The Coal  
Authority

**Re: Planning application 2025/0830**

**Erection of sub-station at 438 Carlton Road, Carlton, Barnsley, S71 3HX**

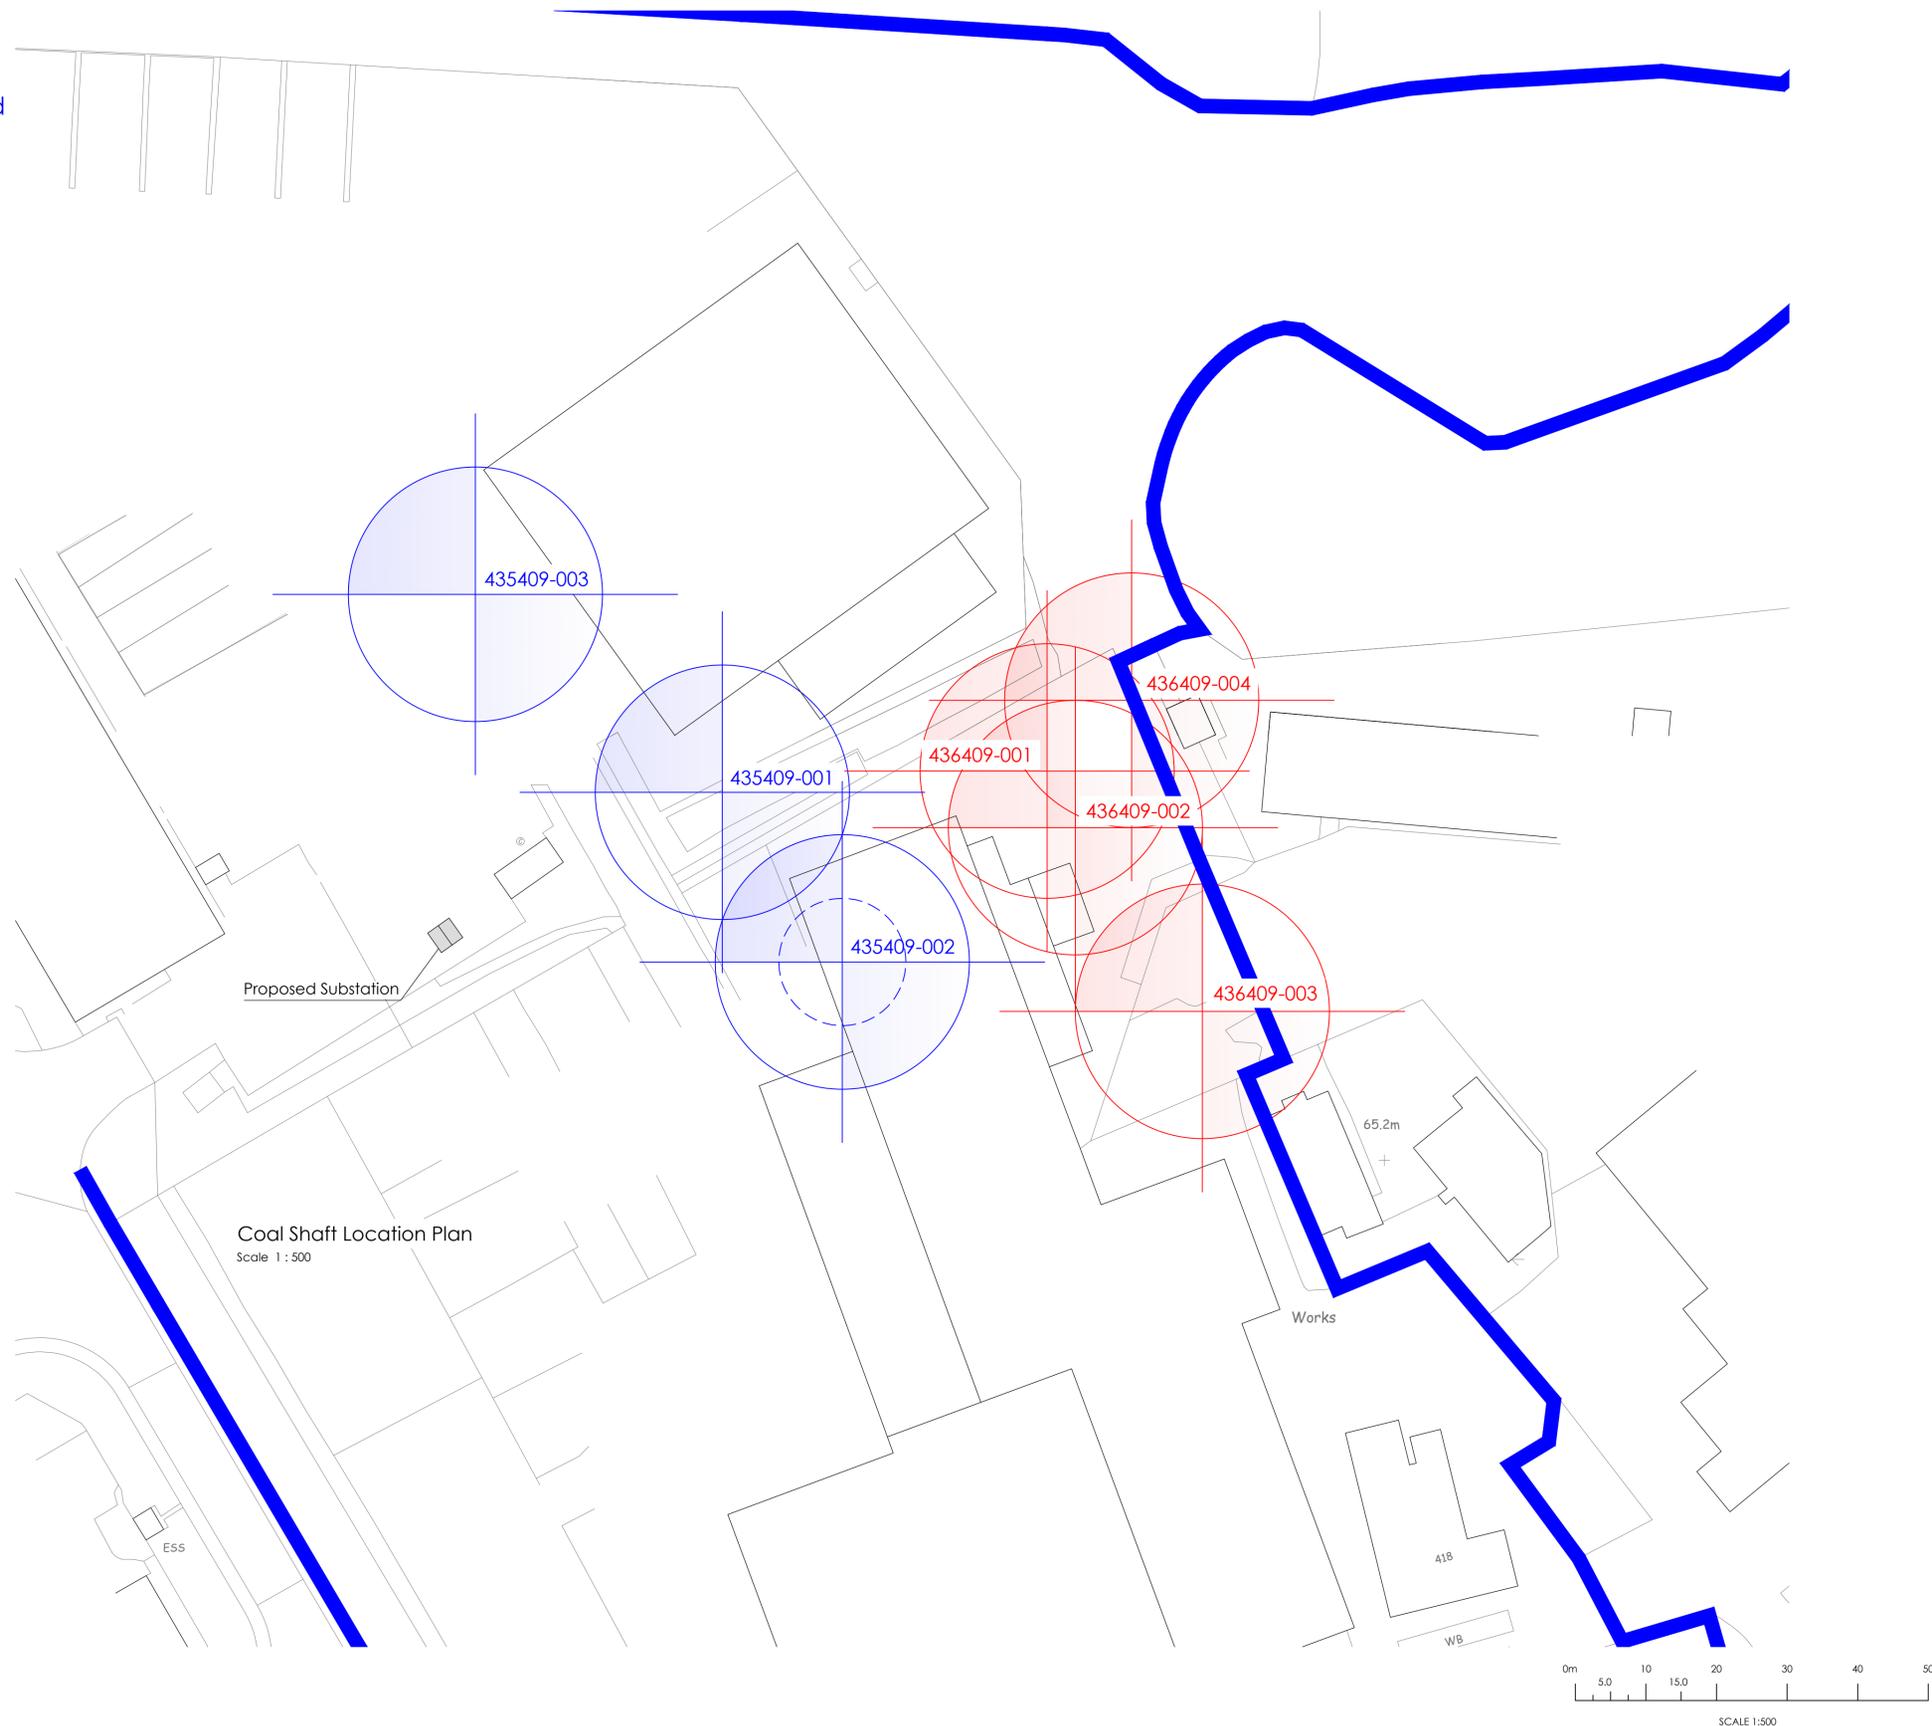
We understand that the LPA is now in receipt of amended plans. We are pleased to note that the proposed substation has been relocated away from the mine entries and is now located within the Development Low Risk Area. As such, the Coal Authority's Planning & Development Team **WITHDRAW OUR OBJECTION** to this planning application.
